Our ref: HA/2019/121572/01-L01
Your ref: AB/88/19/PL

38 NO RESIDENTIAL APARTMENTS (9 NO 1-BED UNITS & 29 NO. 2-BED UNITS) ALONG WITH ACCESS, OFF-STREET PARKING, AMENITY SPACE & ENHANCEMENTS TO THE LOCAL FOOTPATH NETWORK.

LAND AT ELECTRICITY SUB STATION FORD ROAD ARUNDEL BN18 9DX

Environment Agency position

Drawing No.	Rev.
10-12	P4

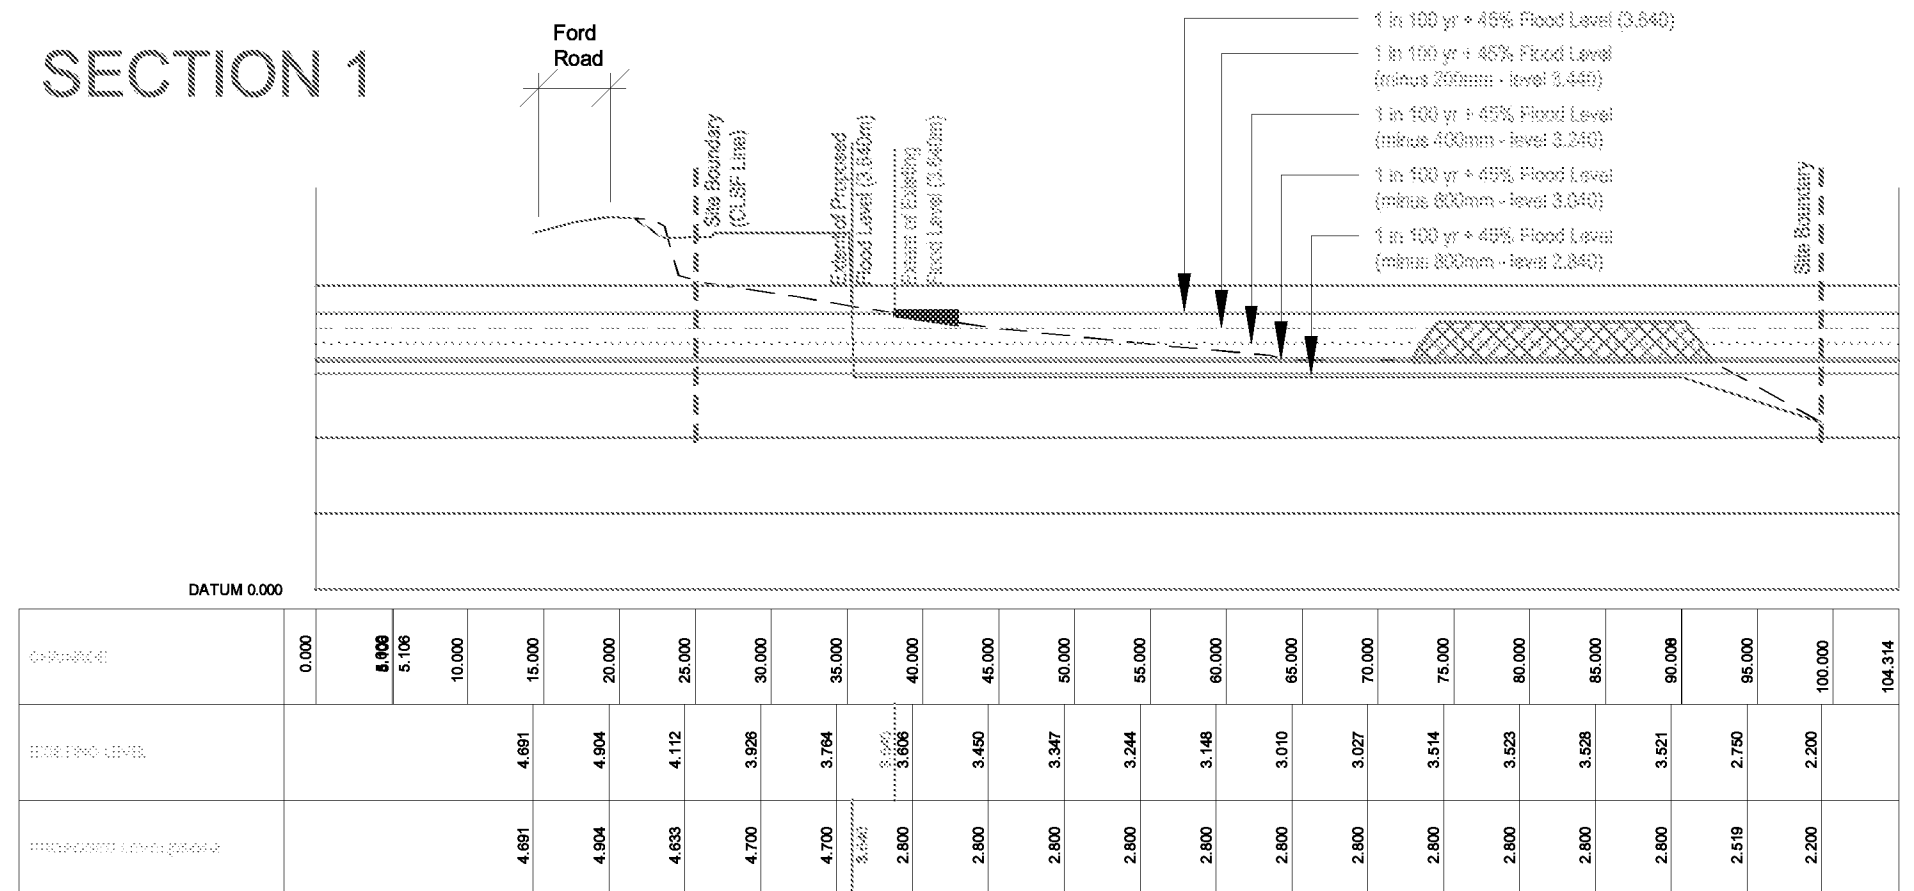
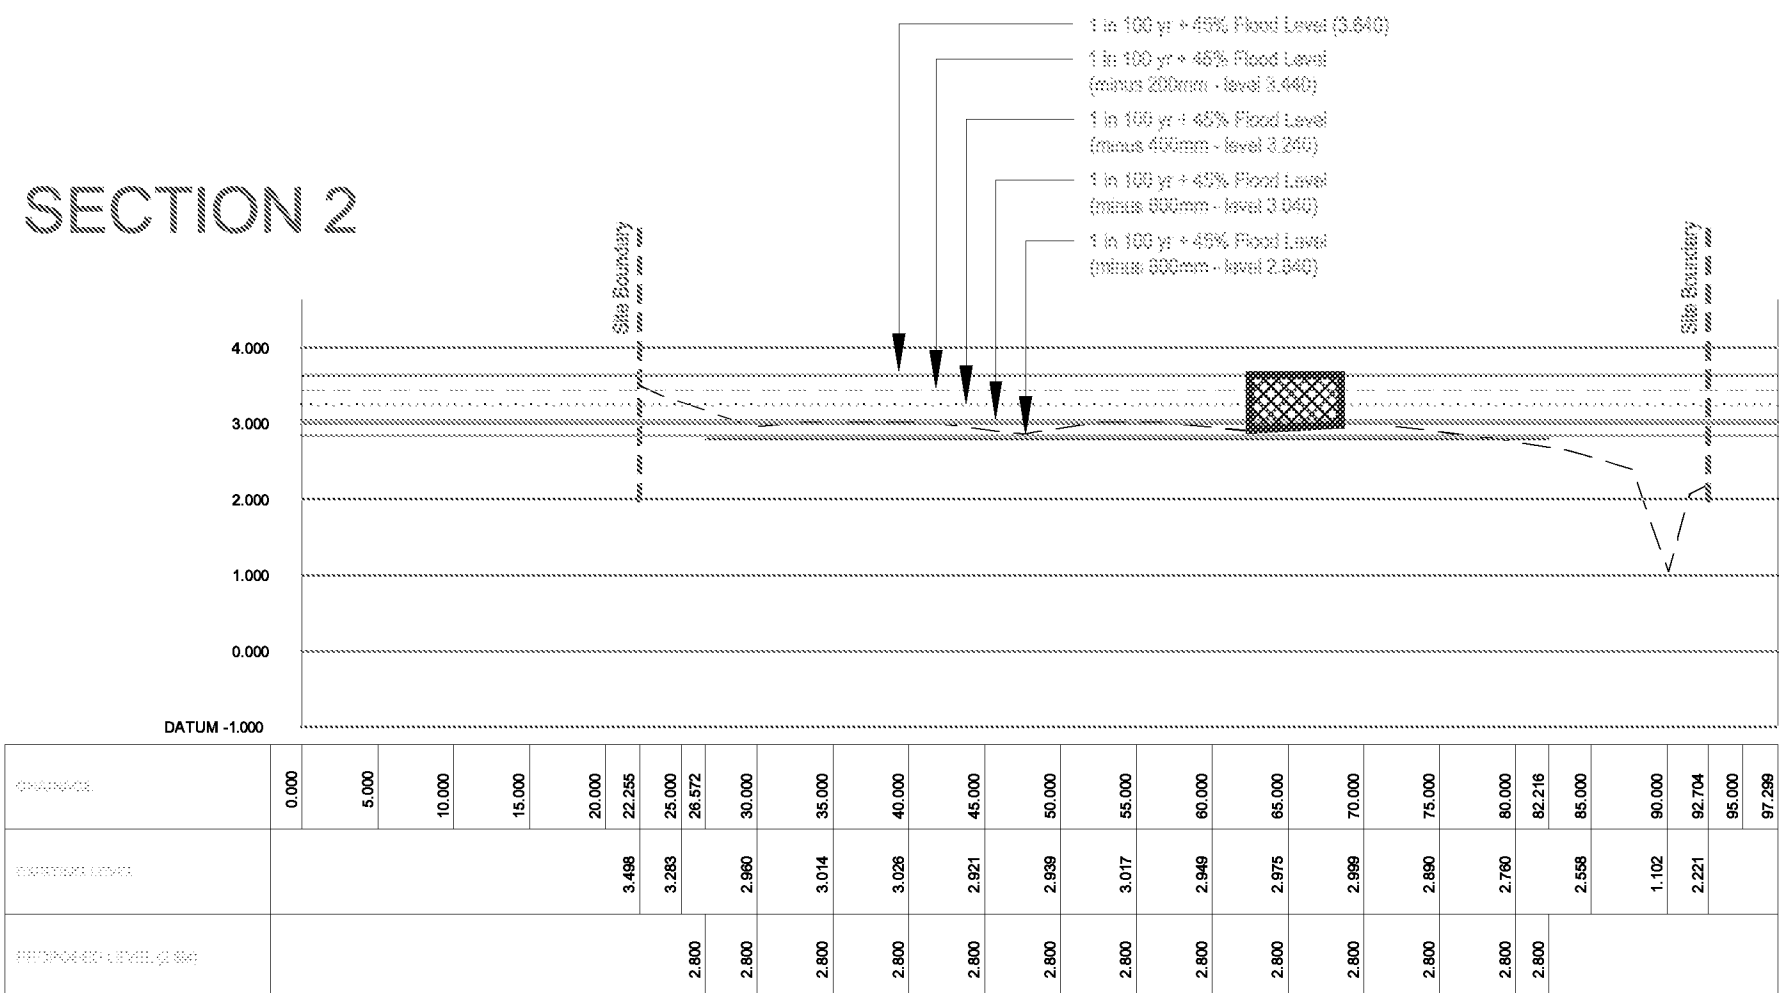
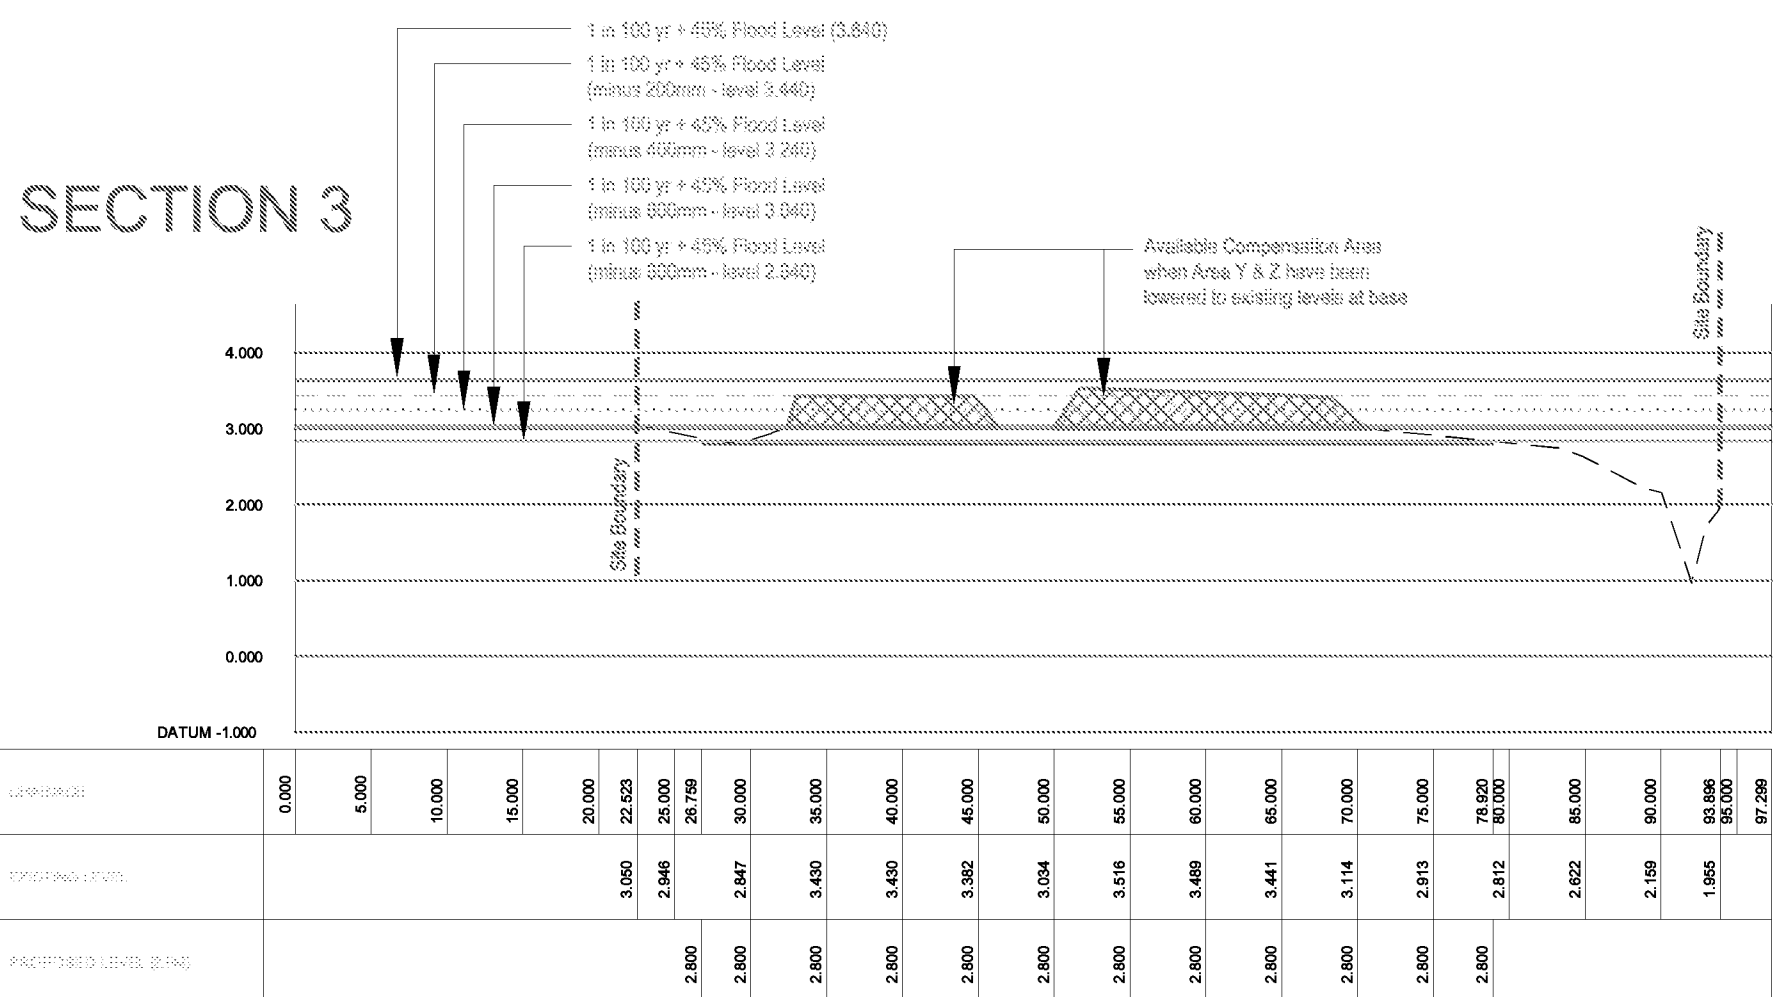
- **Finished floor levels for habitable accommodation shall be set no lower than 5.3 metres above Ordnance Datum (AOD)**
- **Compensatory storage shall be provided in accordance to drawing number 10-12 rev. P4 contained in Appendix N of the FRA.**
